Ribble Valley Borough Council  
Housing & Development Control

Application no: **3/2022/1005**

Address: **Land off Clough Bank Lane Chatburn BB7 4AW**

Proposal: **Proposed erection of two new dwellings and garages to incorporate site redesign of previously approved application 3/2018/0407. Resubmission of refused application 3/2022/0399.**

Client Mr and Mrs Harrison		
Project Proposed Development at Land off Clough Bank Lane Chatburn		
Drawing Title Proposed Site Plan		
Scale 1:200 @ A2	Date Dec 2021	Drawn LFR
READ DESIGN LTD		
137 - 03 c

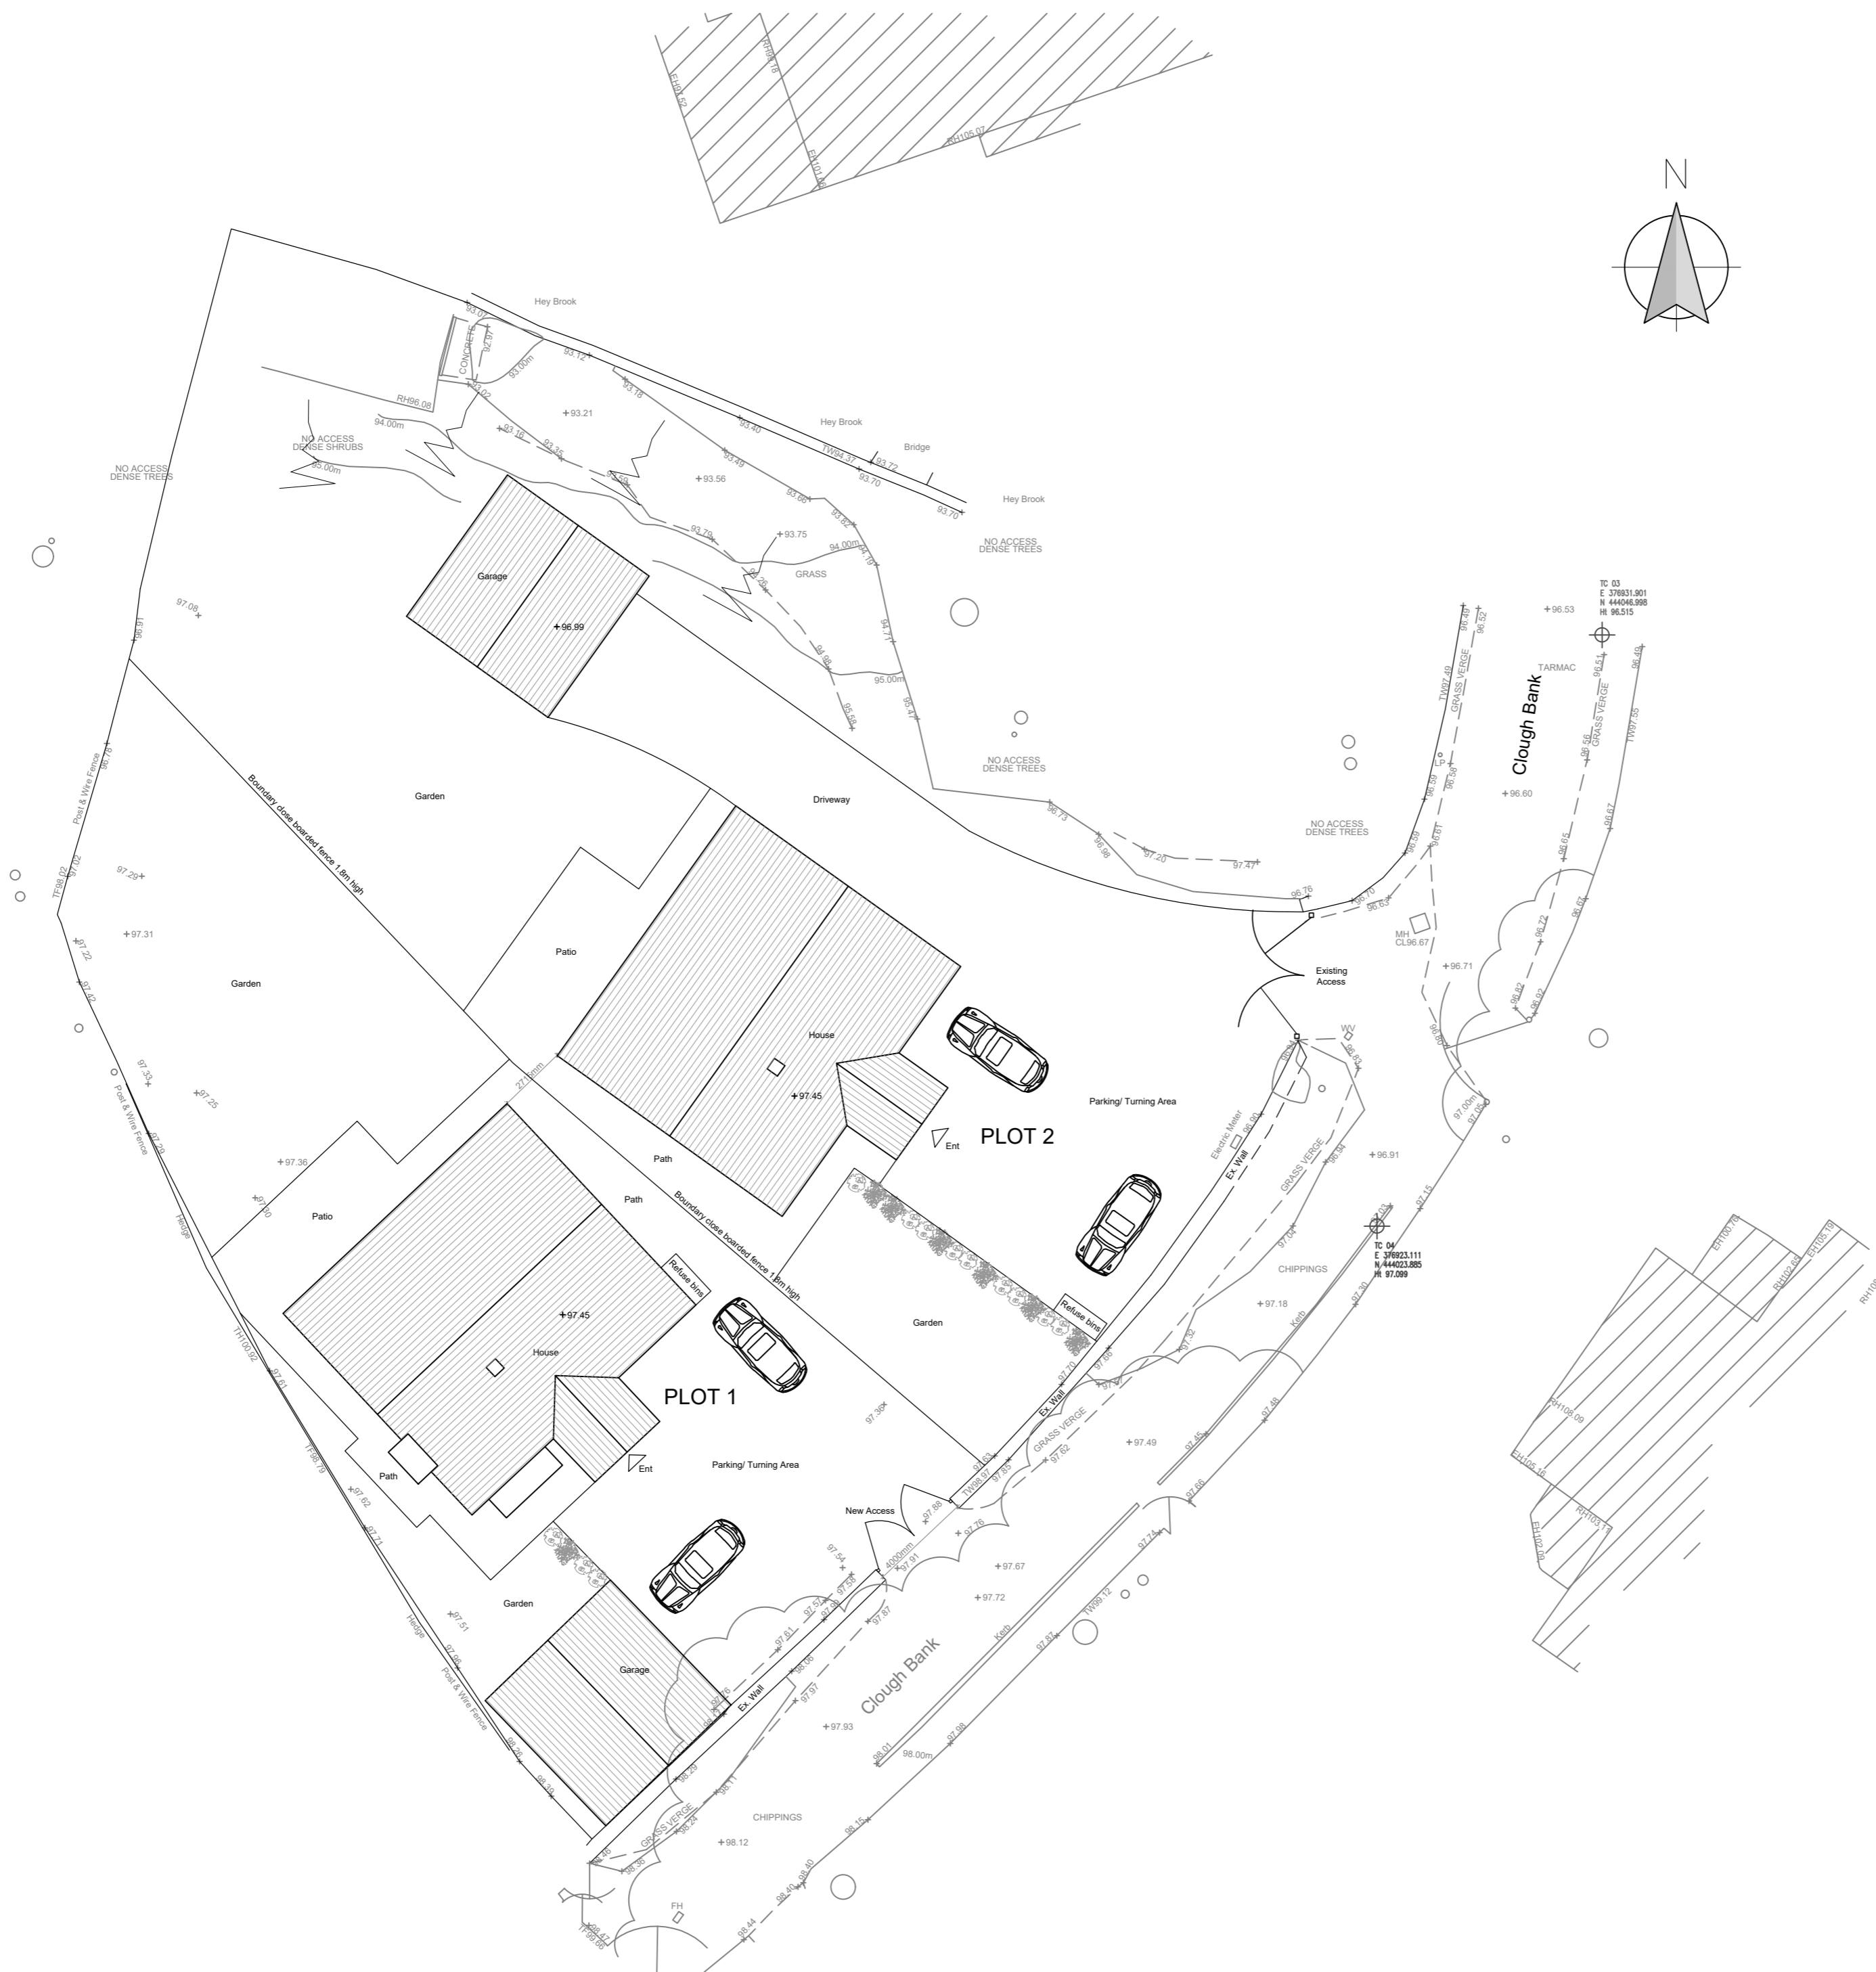
Internally, as shown on Read Design drawing number 137-03C titled "Proposed Site Plan," each dwelling will have its own private, access which will be gated.

Plot 2 will use the existing access which is used to access the vacant land from Clough Bank Lane, while Plot 1 will use a new access from the private track which will be erected following the proposal.

While the LHA advise that the access gates are setback 5m behind the access track and that the boundary walls within the access's visibility splays are lower than 1m, the LHA have no objection to the proposal.

The LHA have further reviewed Read Design drawing number 137-03C titled "Proposed Site Plan," and it's worth noting that the parking arrangements found at each dwelling complies with the parking guidance found in the Joint Lancashire Structure Plan.

The LHA also inform the Applicant that should any works to the site be conducted a maximum of 3m from the stream then an agreement with the Lead Local Flood Authority is required. Please see the informative below for more details.

2. The development hereby permitted shall not be occupied until such time as the parking and turning facilities have been implemented in accordance with Read Design drawing number 137-03C. Thereafter the onsite parking provision shall be so maintained in perpetuity.
